Tuck O'Brien  
City Planning Director, Planning Division

April 11, 2016

Project Name:	Interior Renovation/ Addition	Project ID:	2015-138
Address:	35 Pleasant Street	CBL:	C39 F023001
Applicant:	Lauren Reiter		
Planner:	Shukria Wiar

On April 11, 2016, the Planning Authority approved with conditions a Level II site plan for a building addition to the structure at 35 Pleasant Street. The proposed building addition expands the existing residential use by adding one story to the rear of the building and expands the building over the existing parking area to create a garage and upper floor residential space. This project includes a construction analysis from the construction company outlining how the building expansion to the property lines can be achieved from the applicant's property and will not affect adjoining properties during construction. The applicant has a construction easement along the property boundary for 14 South Street. The decision is based upon the application, documents and plans as submitted by and prepared by Lauren Reiter with a revised date of 03.24.2016. The proposal was reviewed for conformance with the standards of Portland's site plan ordinance.

Survey & Site Info

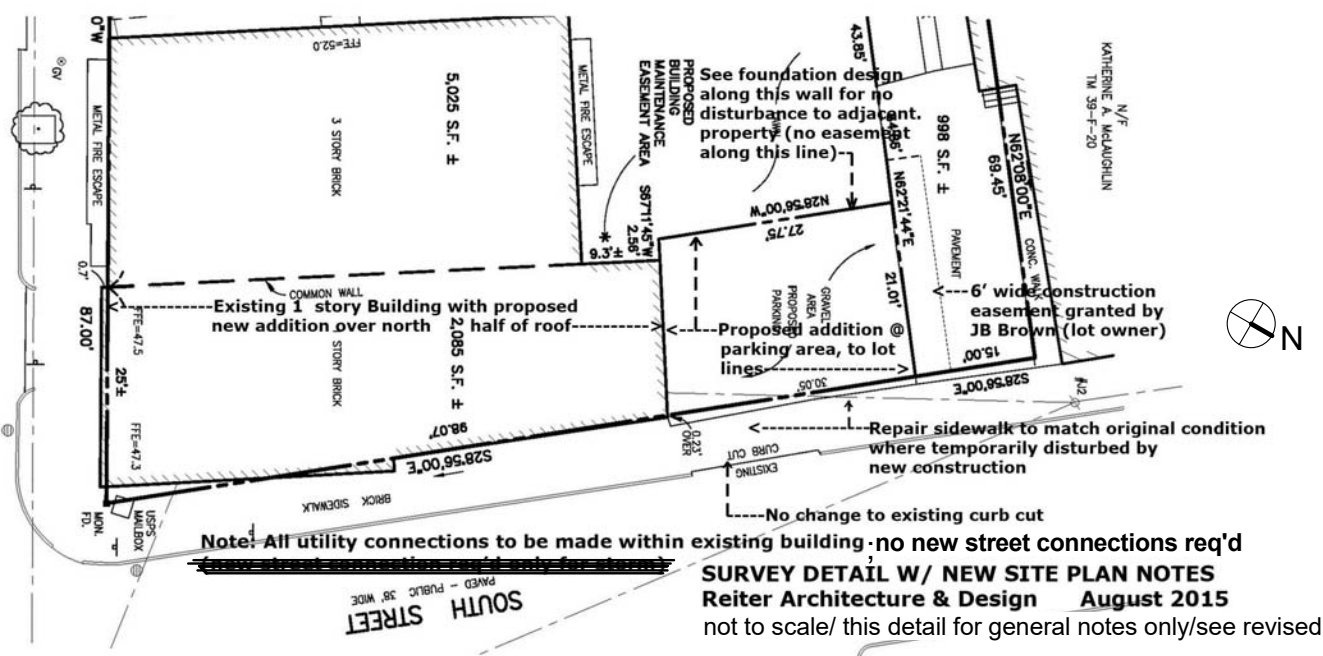
1. The applicant shall cleanly cut any disturbed roots of the Elm tree, on the abutters property at 37 Pleasant Street during construction and be watered if conditions are dry. Deadwood shall be pruned next dormant period as not to attract elm bark beetle to the new wound wood. The applicant shall follow 'best management practices', refer to <http://www.treesaregood.com/treecare/resources/ConstructionDamage.pdf>.
2. Based upon Lauren Reiter's email dated 03.28.2016, the proposed garage will be a two bay garage (the two bays on the southerly side of garage and in line with existing curb cut) for the parking of motor vehicles. The third bay closest to the northerly property line shall not be used for motor vehicle parking space. The doors for the third bay shall not swing onto the City's right-of-way.
3. The site work and general notes #1 and #4 on Plan A101 shall be deleted from the plan.
